# CITY OF ALBUQUERQUE

**Re: Menaul Shopping Center, Wyoming & Menaul  
Grading and Drainage Plan  
Engineer's Stamp dated 09-30-10 (H20-D002)**

**RE: Grading and Drainage Plan  
Menaul Shopping center(H20-D0002)**

ENGINEER'S SEAL	MENAU SHOPPING CENTER	DRAWN BY: WCWJ
	GRADING AND DRAINAGE PLAN	DATE: 8-24-10
	 Rio Grande Engineering 1606 CENTRAL AVENUE SUITE 201 ALBUQUERQUE, NM 87106 (505) 872-0999	2129-LAYOUT-8-23-10
DAVID SOULE P.E. #14522		SHEET #
		JOB # 2129

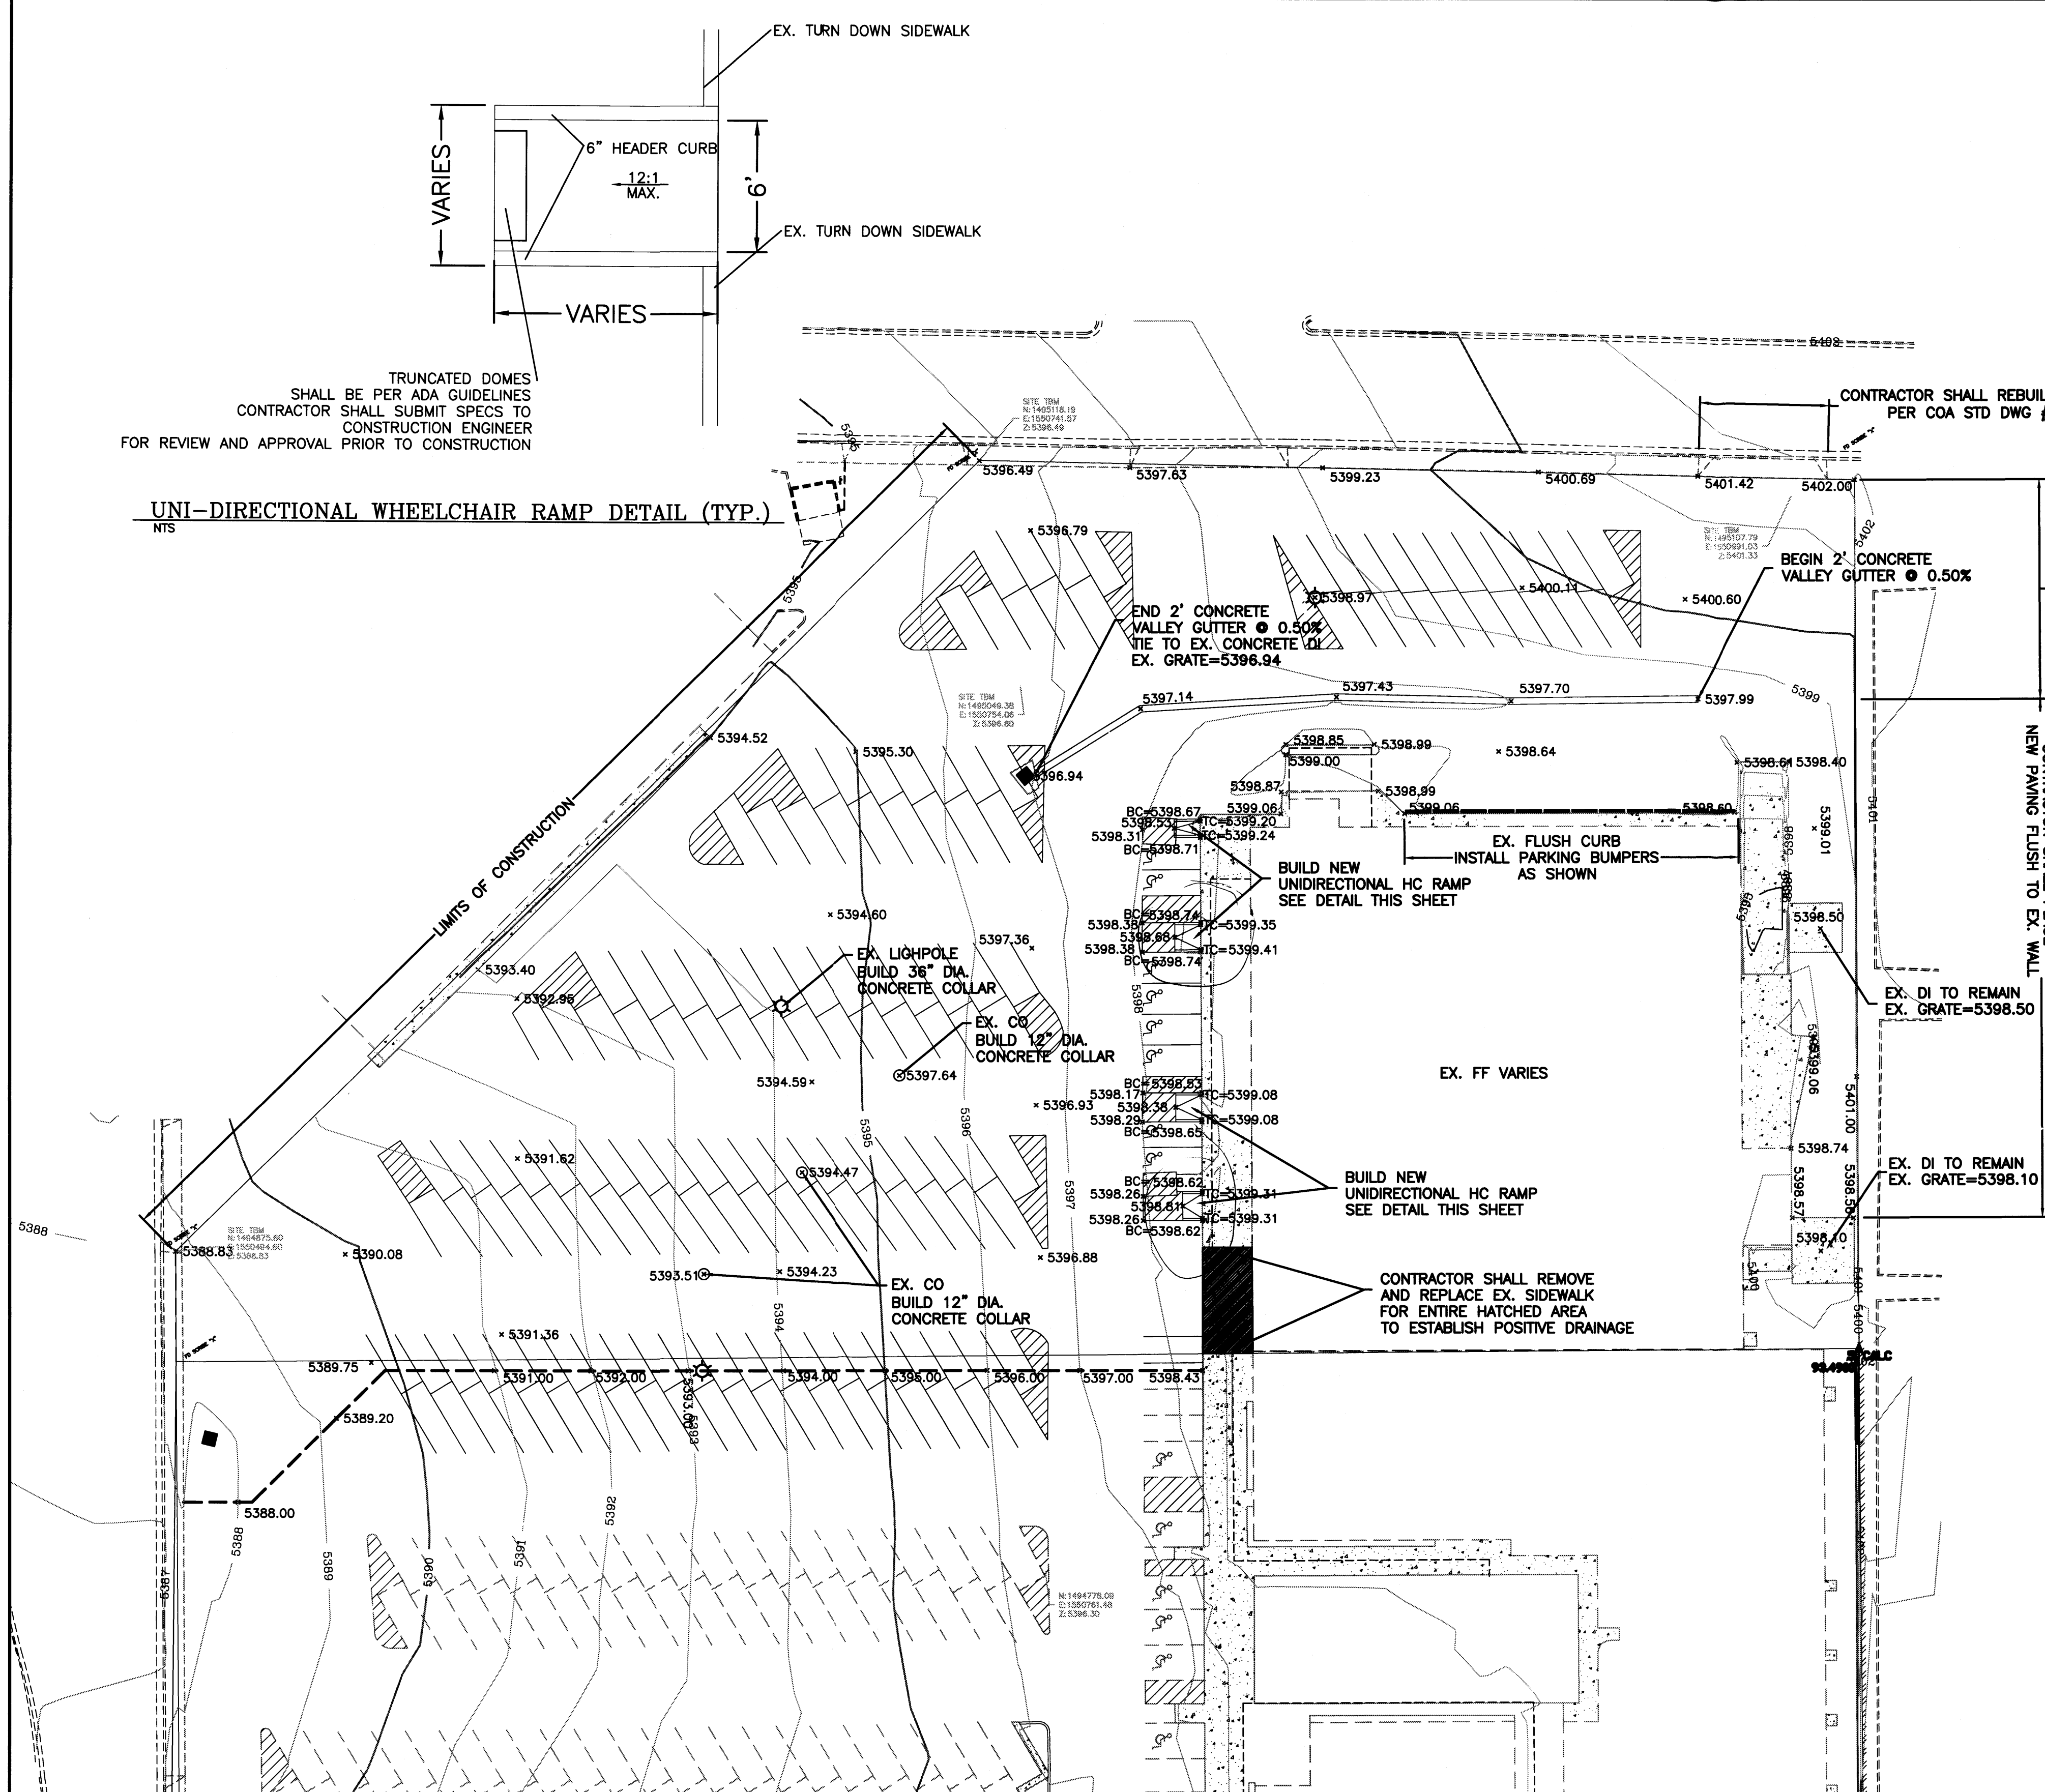
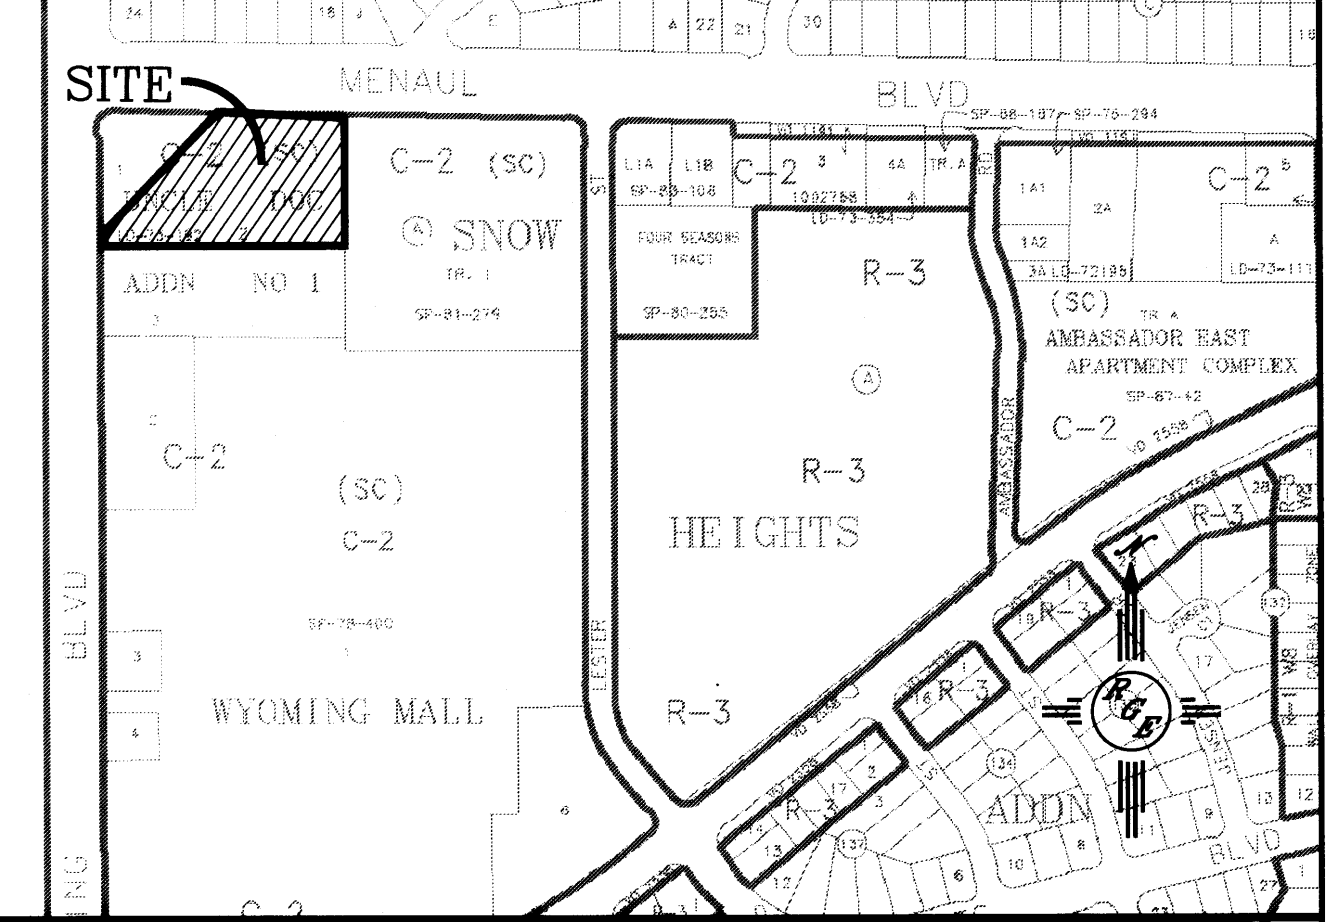
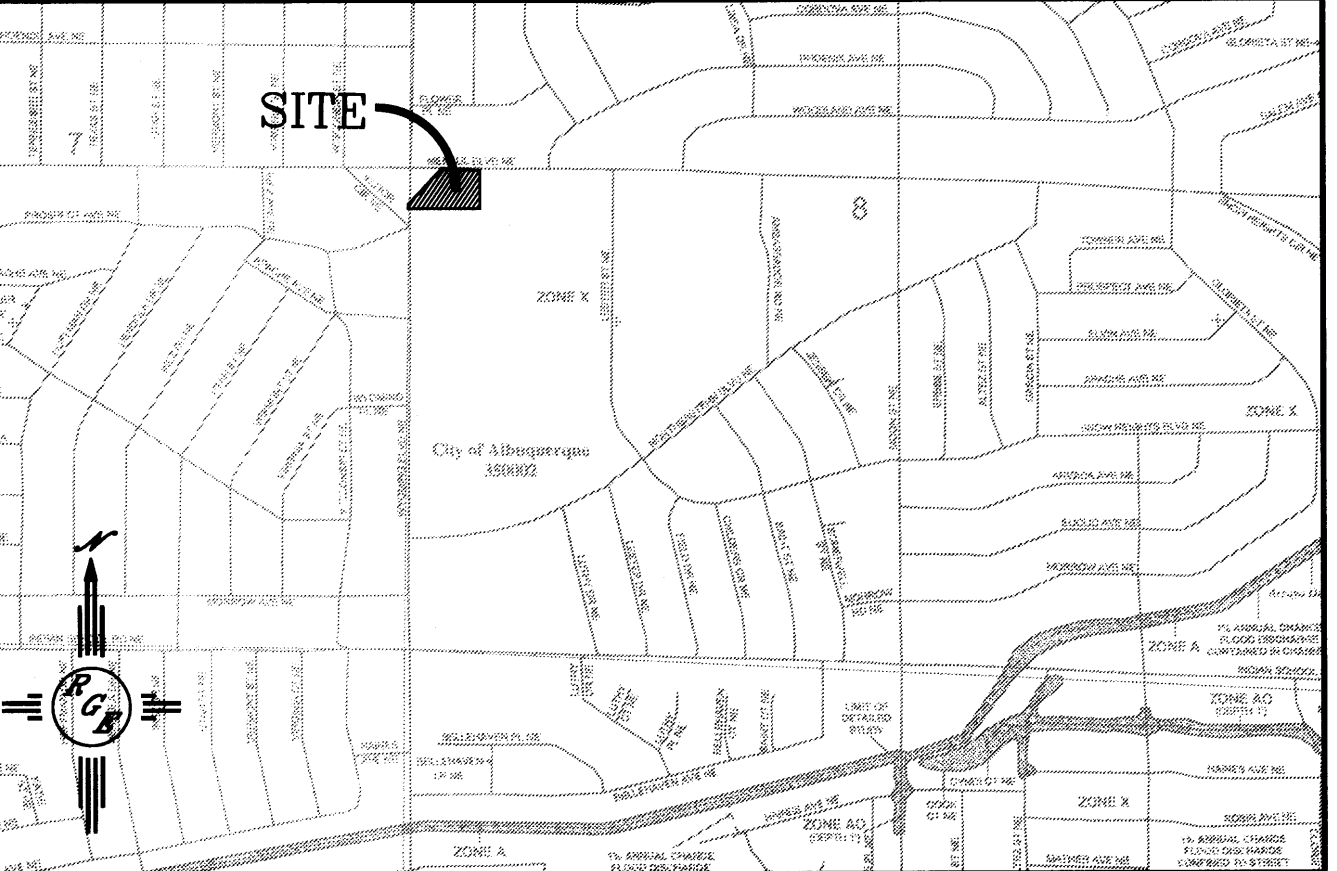
1. Are you matching existing paving at the limits of construction?

2. What is top of Concrete near the building on the west side?

3. The dashed line near Menaul, which appears to be a trash bin enclosure. Is this being replaced or left as is

**Yes.**

**The spot call outs have been clarified as to top of curb. The sidewalk varies between 99.08 and 99.41.**

**It is an existing trash enclosure, and offsite. No work will be performed in this area.**
